Application correspondence

From: Simon Davis
Sent: 12 July 2018 10:03
To: 'Stephen Penfold'
Cc: 'Richard Atkinson'; 'Sue Frodsham'; Laura Gibbons
Subject: RE: Sack Lane, Lidsey, West Sussex - Planning Application No. AL/60/18/DOC

From: Laura Gibbons
Sent: 12 July 2018 09:57
To: 'Stephen Penfold'
Cc: Simon Davis; 'Richard Atkinson'; 'Sue Frodsham'
Subject: RE: Sack Lane, Lidsey, West Sussex - Planning Application No. AL/60/18/DOC

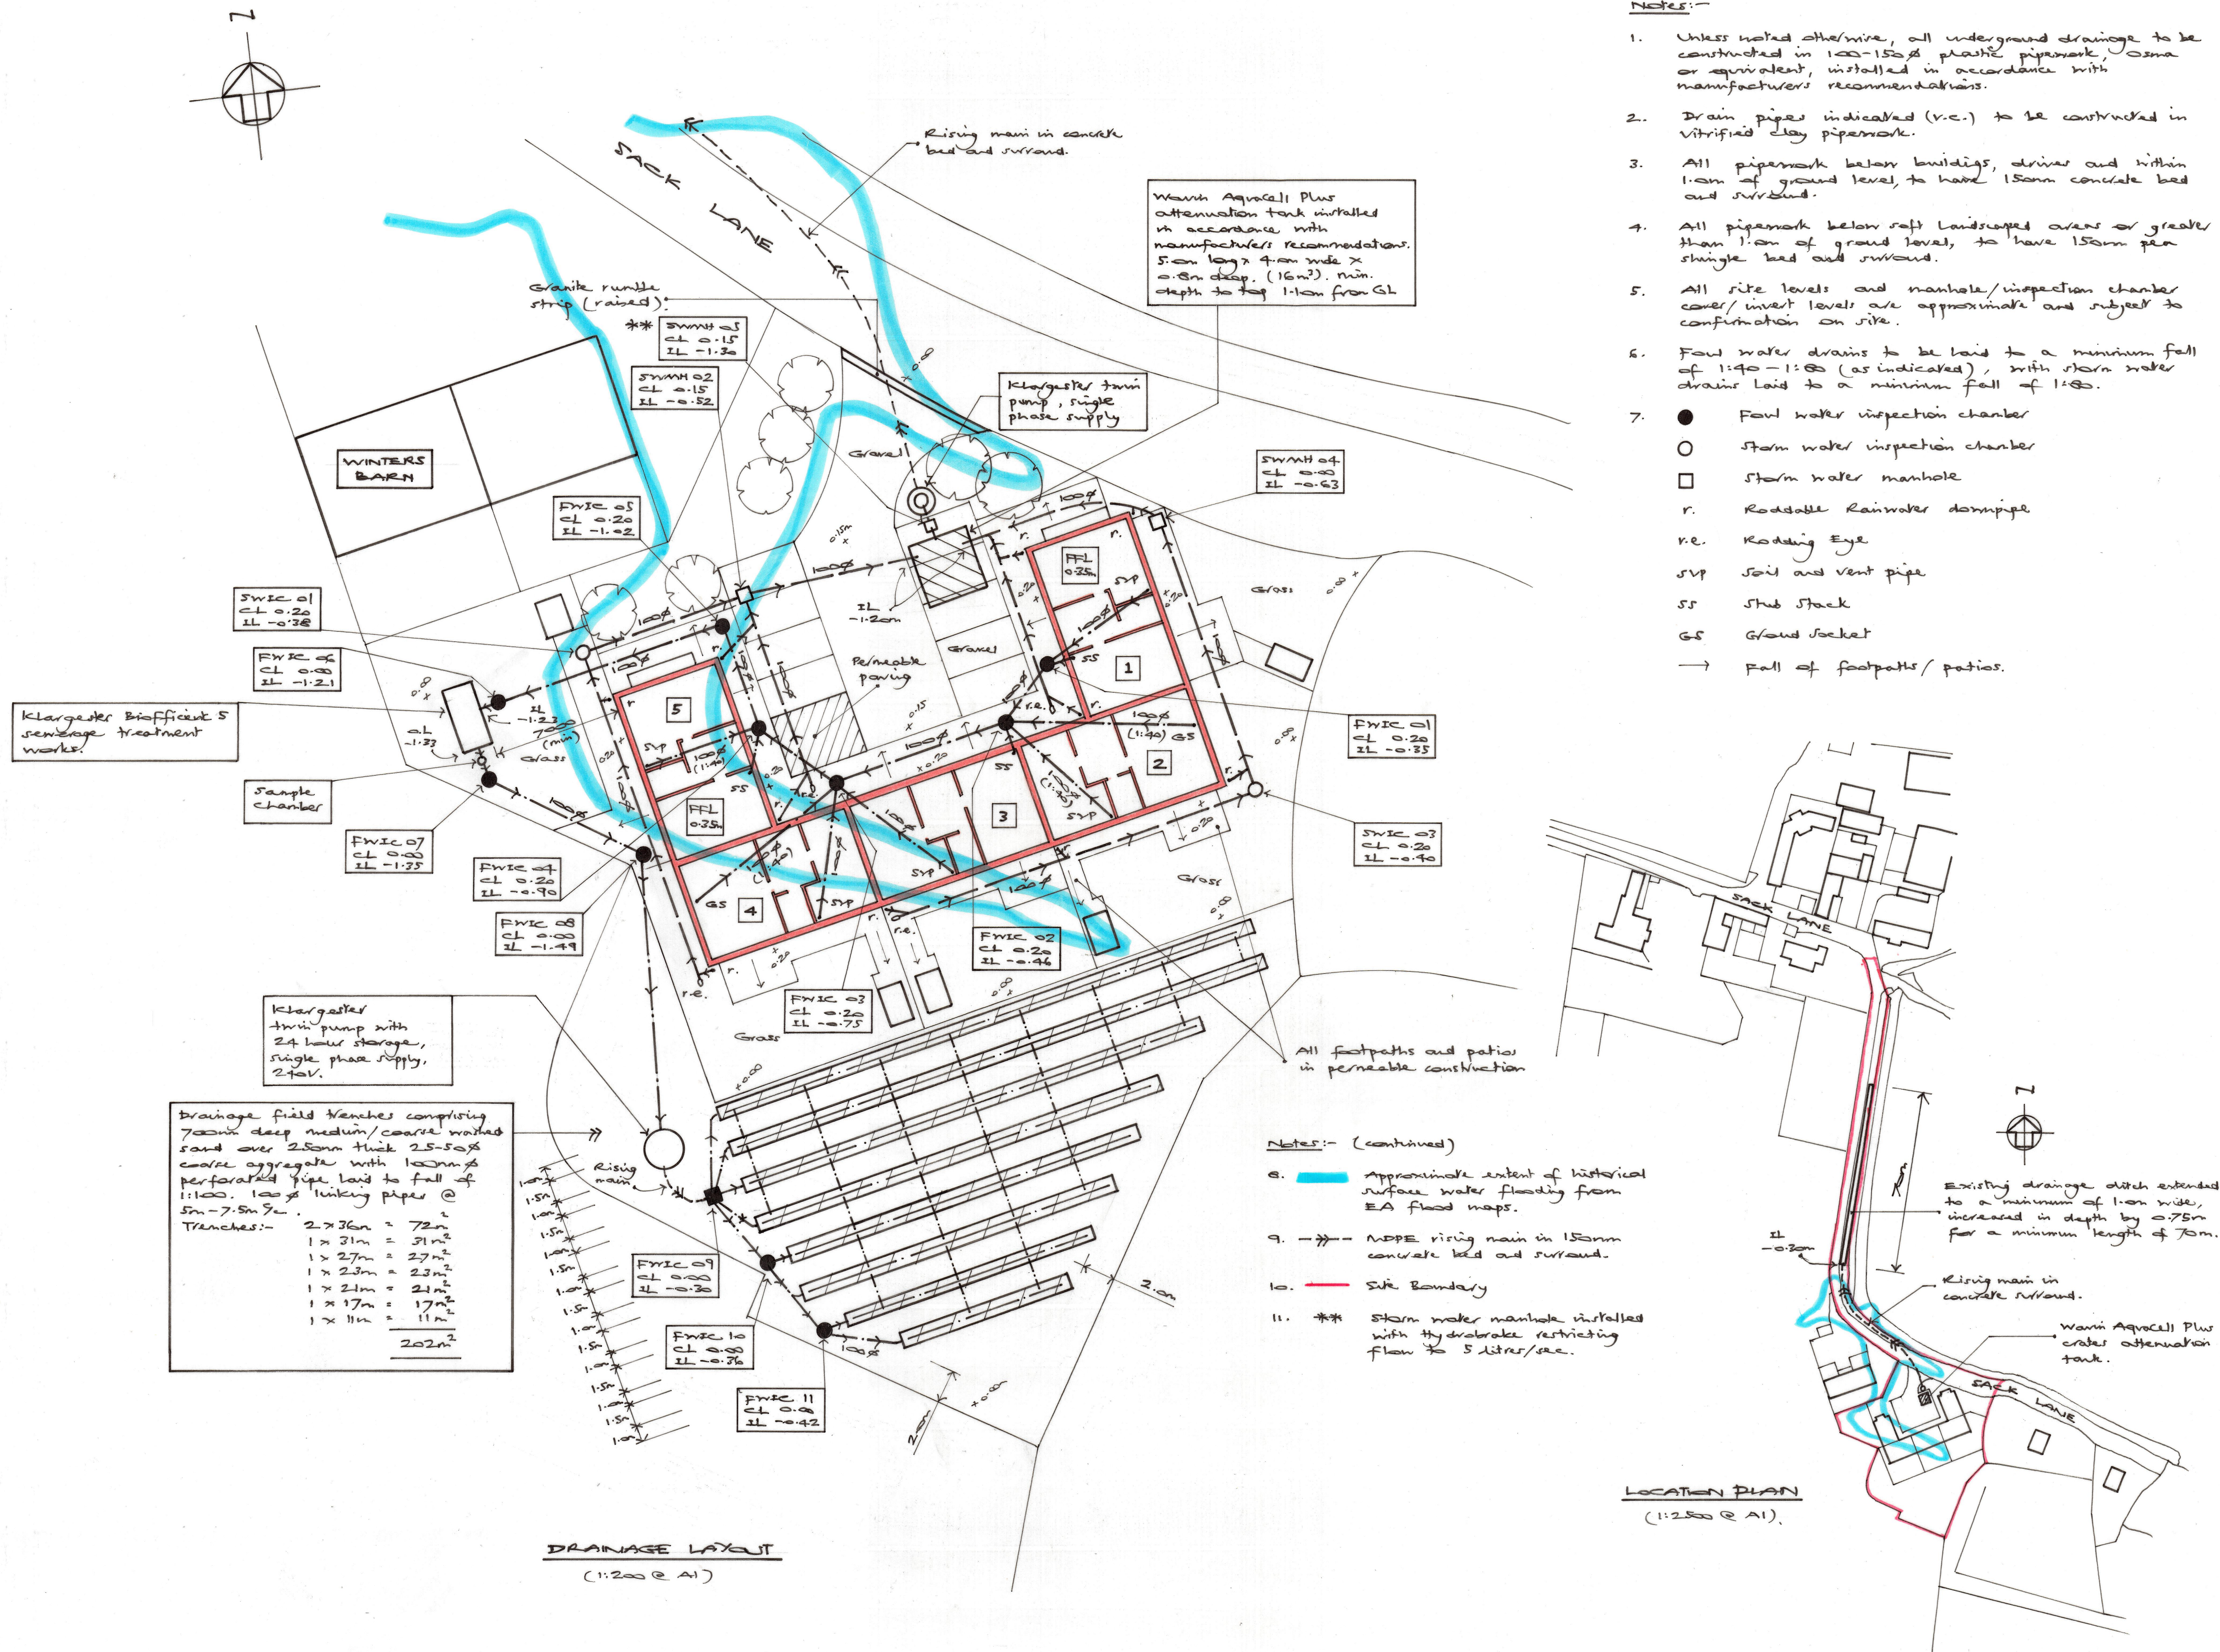
The plans show that you are planning on attenuating surface water on site and then pumping this to discharge to the ditch, which is off site. Please investigate infiltrating surface water on site, i.e. use of a soakaway (set at least 5m away from any building) instead of the attenuation tank. If this is located appropriately it would remove the need for pumping and discharging to the ditch.

I note that the red line site boundary shown on the drainage layout plan is significantly different to that submitted as part of the original planning application. Please correct this on the drainage layout.

1. Neither ourselves or the applicant want install any pumps. The purpose of incorporating these is simply to raise the discharge levels above any elevated winter groundwater levels, which it will do.
2. Surface water is being discharged via infiltration through the drainage trench.
3. See below.
4. Surface water is controlled through a hydrobrake installed through manhole SWMH 05, limiting flow to 5 l/s, as stated on our drawing no. 18094/100'B'.

If monitoring indicates winter groundwater levels are very high, then we will have no option but to adopt the last resort of pumping, as indicated on our drawing no. 18094/100'B', as this is the only method to raise discharge levels above it. Similarly, if further winter infiltration testing shows the values used in the design submitted are too low, then the size of the drainage trench and drainage field can be increased within the site boundaries.
